Planning Inspectorate

Our Ref: EN010162

Application by Elements Green Trent Limited for an order granting development consent for the Great North Road Solar and Biodiversity Park

Advice following issue of decision to accept the application for examination

Camera: Sony ILCE-7C

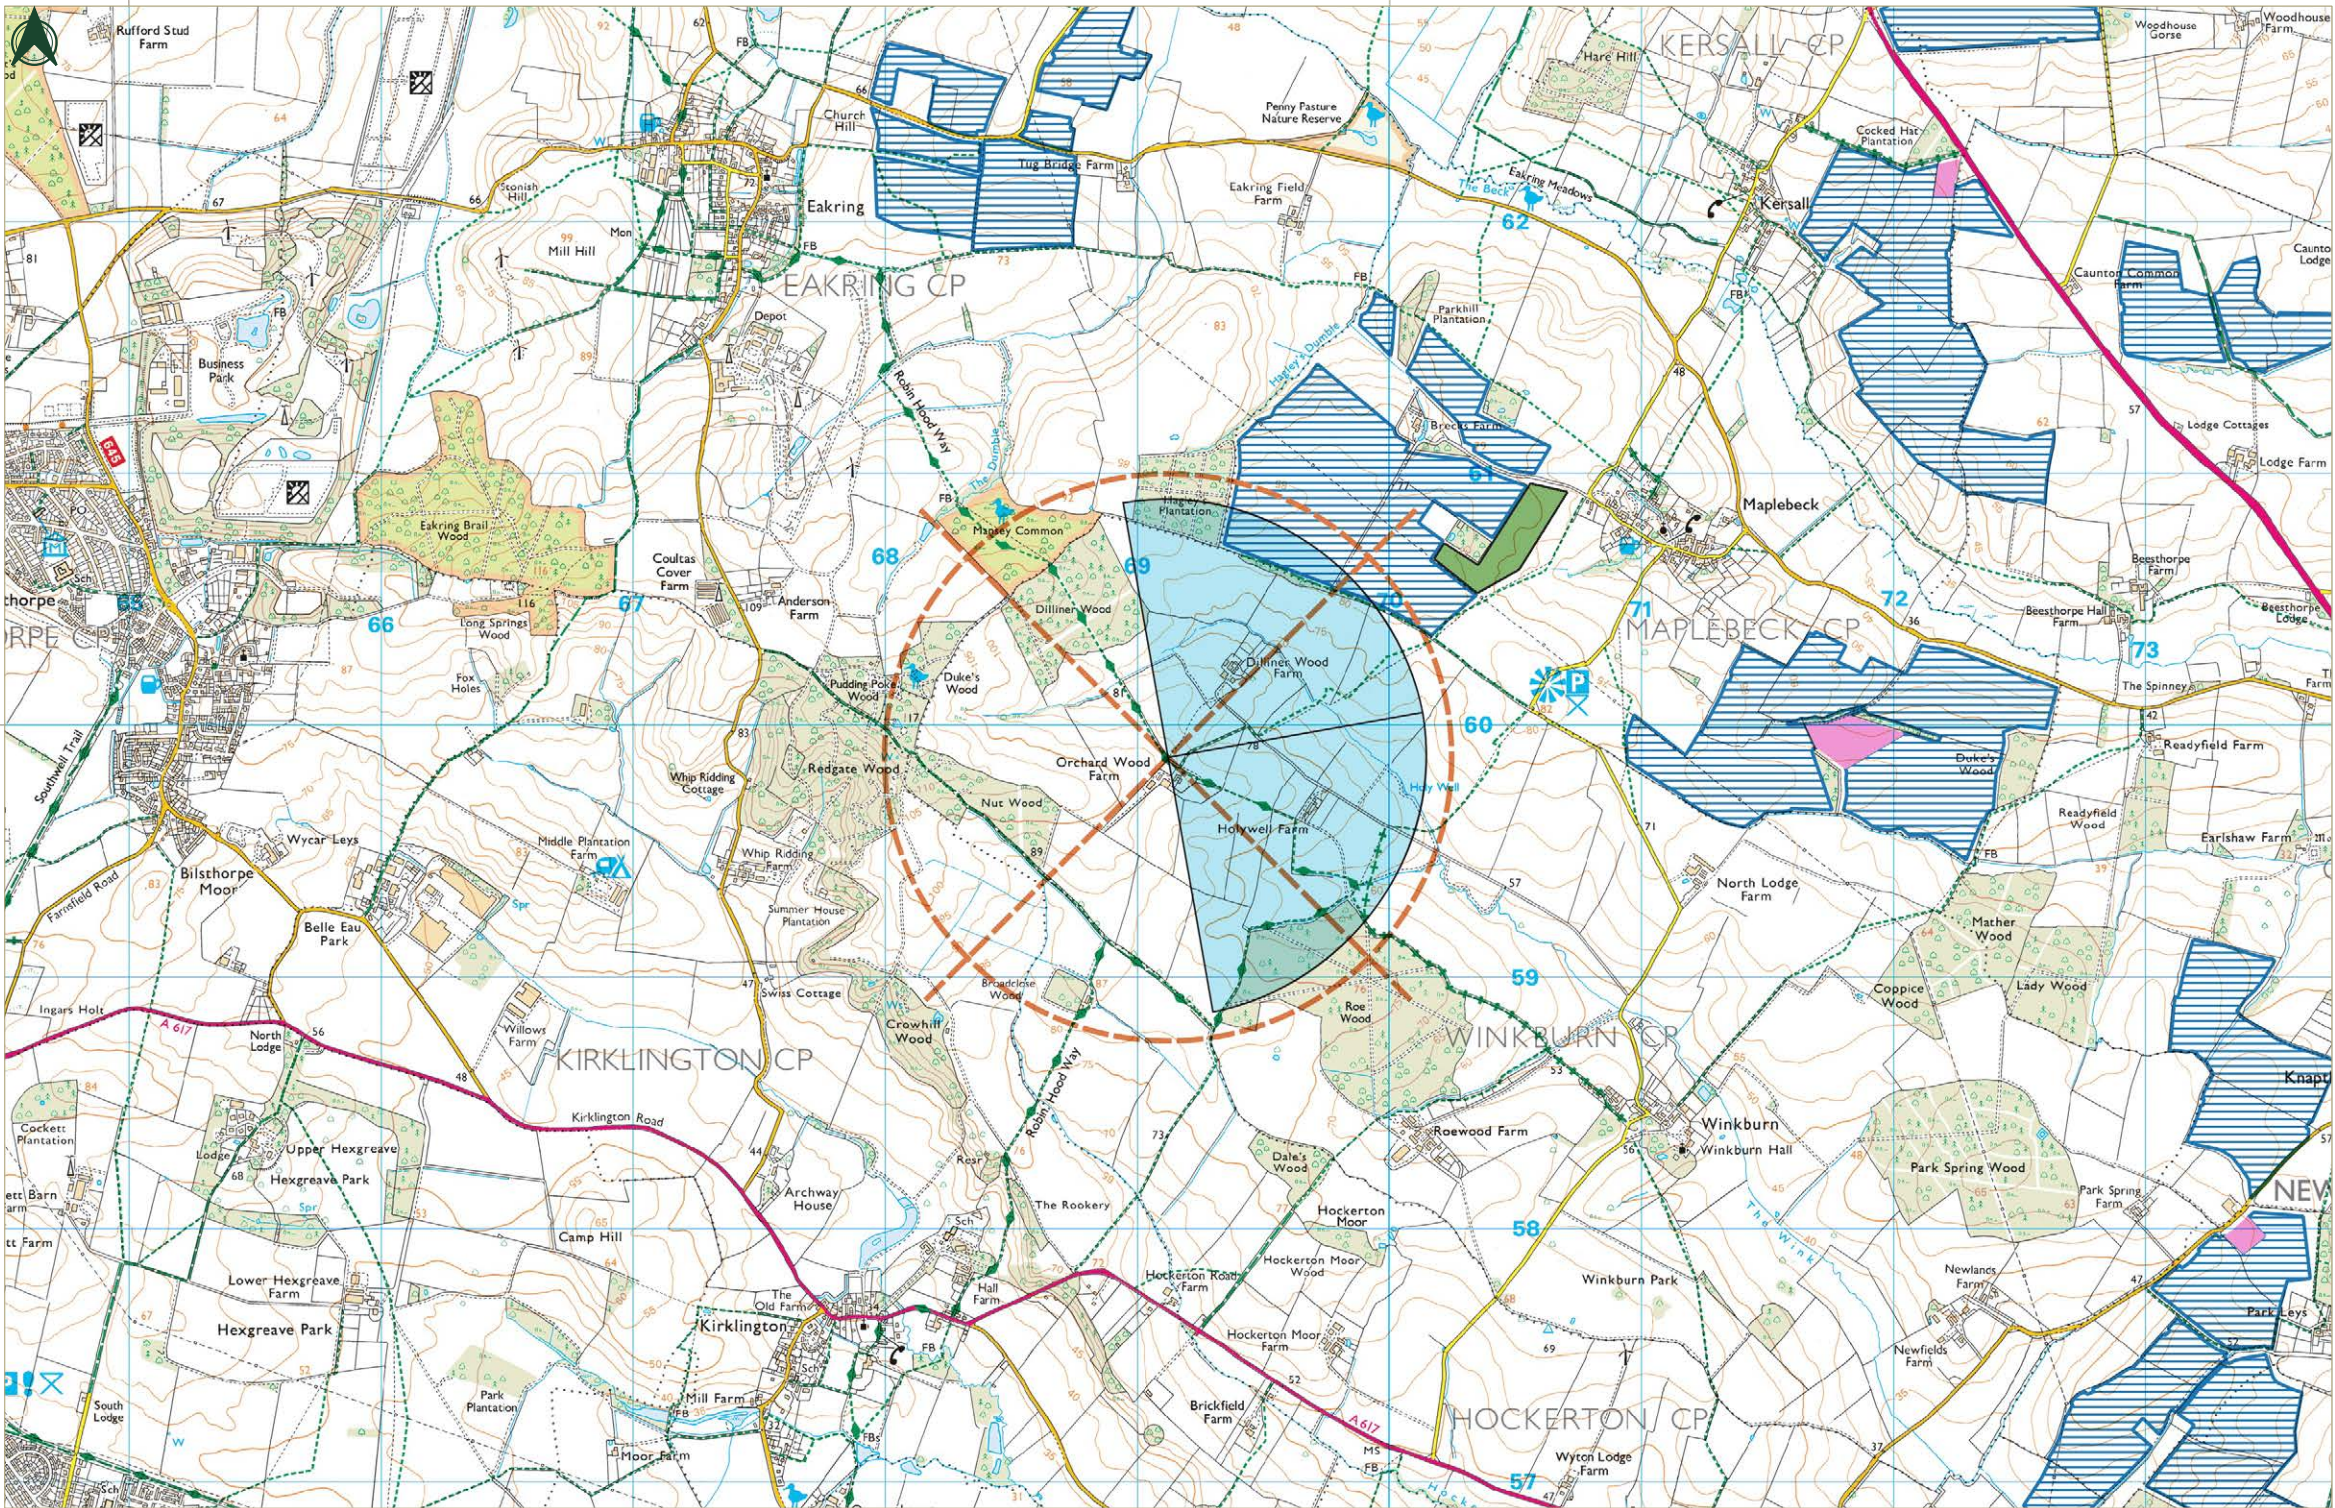
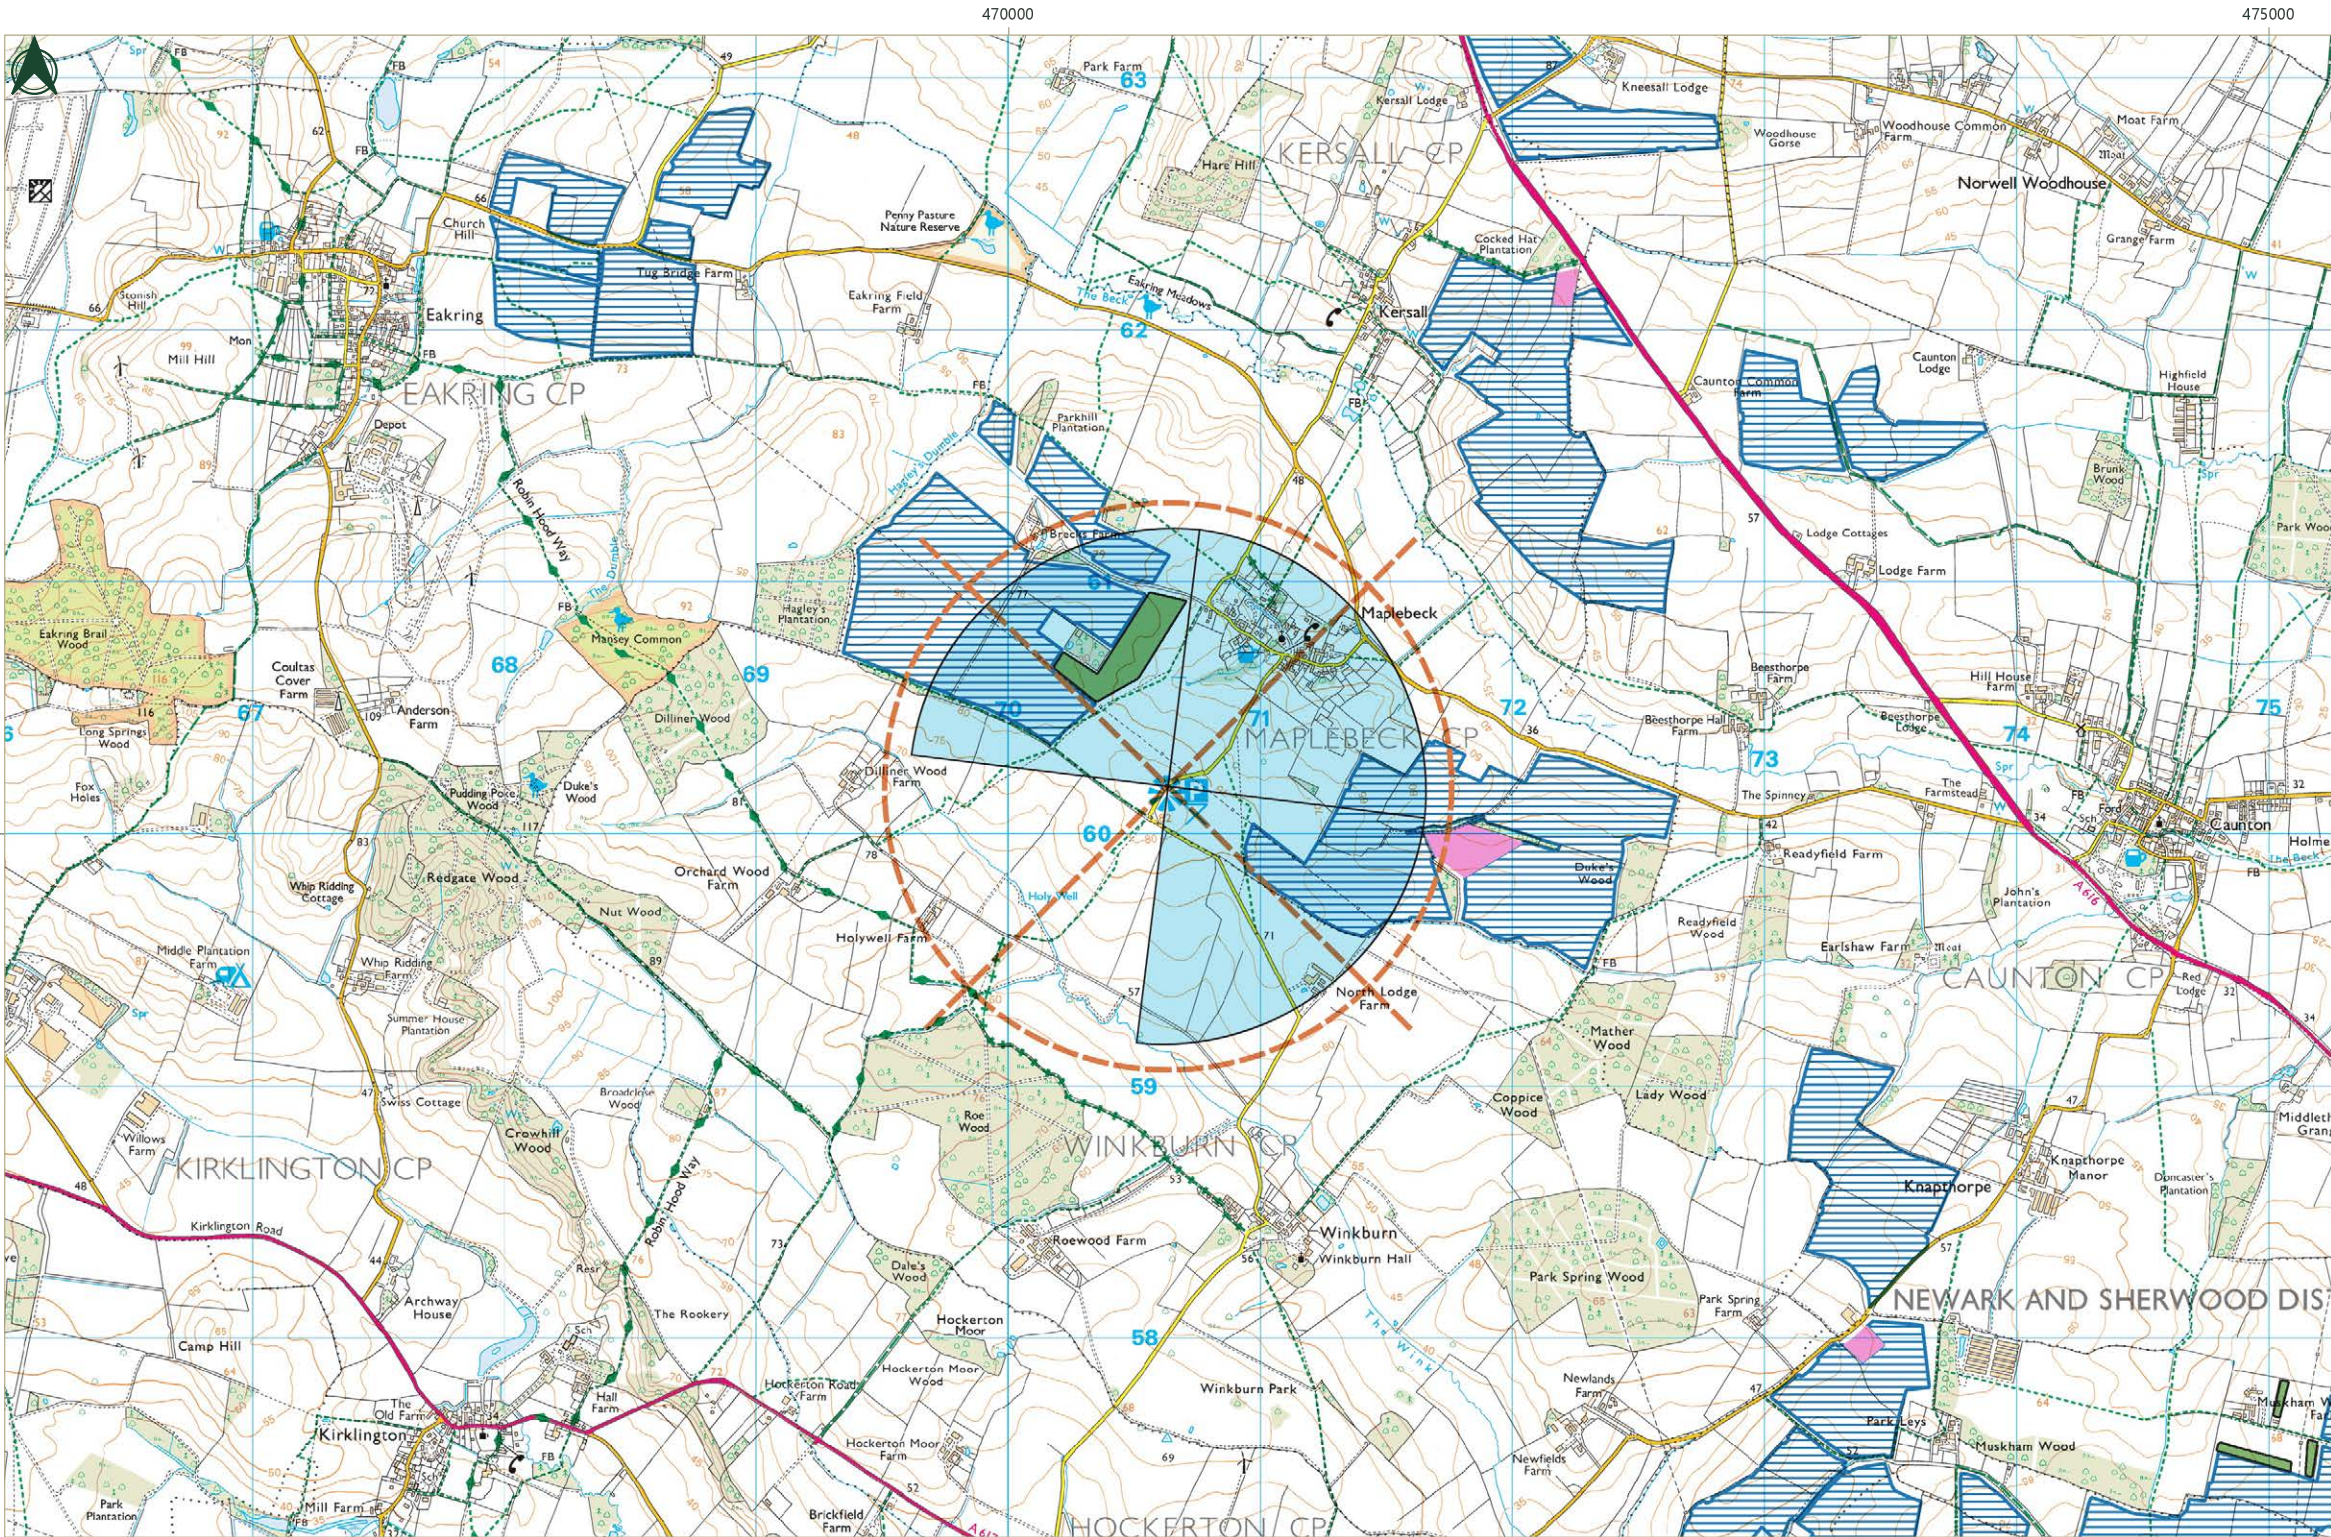
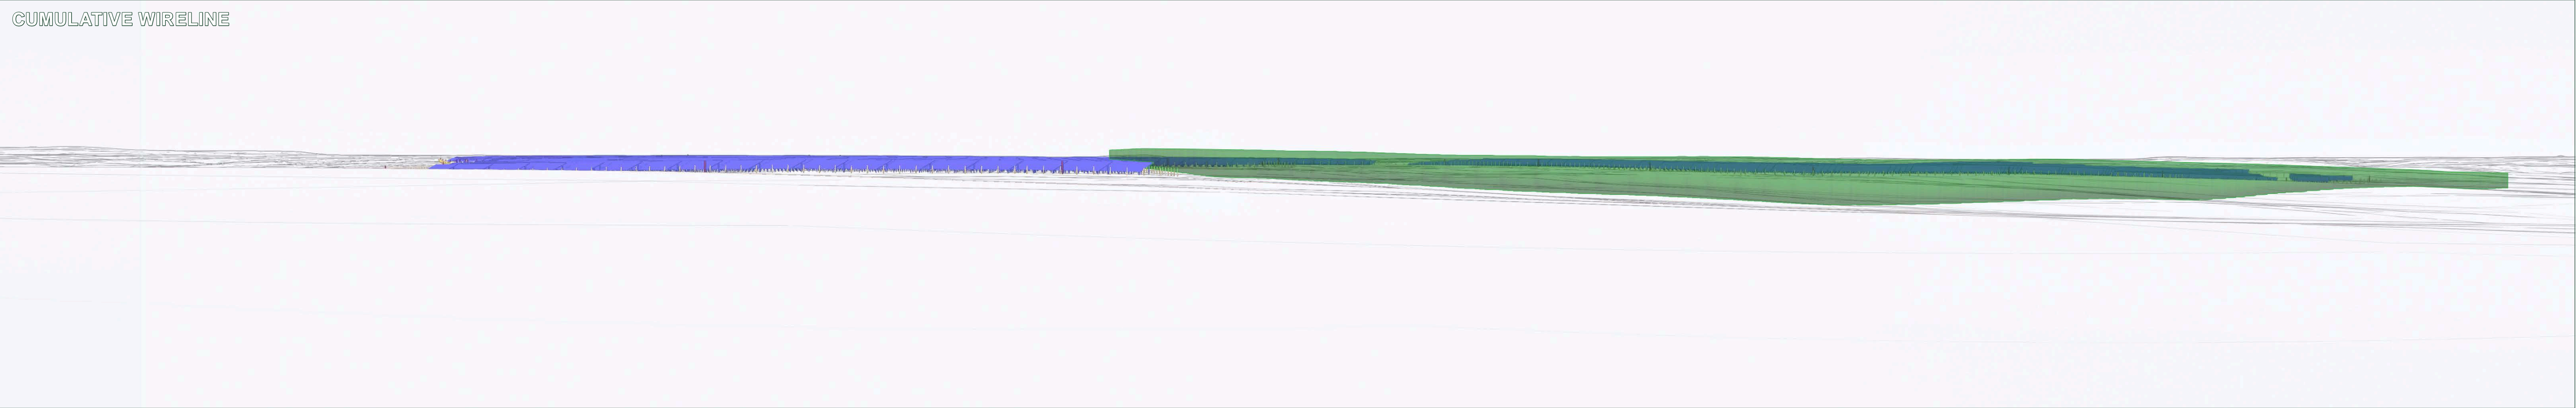
Environmental Statement (ES), Chapter 7, figures 6.3.7.11.1 – 6.3.7.11.55

The Landscape and Visual Impact Assessment (LVIA) contained within the ES, Chapter 7 details the analysis undertaken for 55 viewpoints from the visualisations contained within figures 6.3.7.11.1 – 6.3.7.11.55. The technical appendix detailing the methodology also refers to photomontages and wireline modelling where required.

However, the visualisations and photomontages do not appear to have been provided, as figures 6.3.7.11.1 – 6.3.7.11.55 contain only the location plan of the viewpoint as well as its description. We request that the applicant provide these visualisations and photomontages ahead of the opening of the relevant representation period.
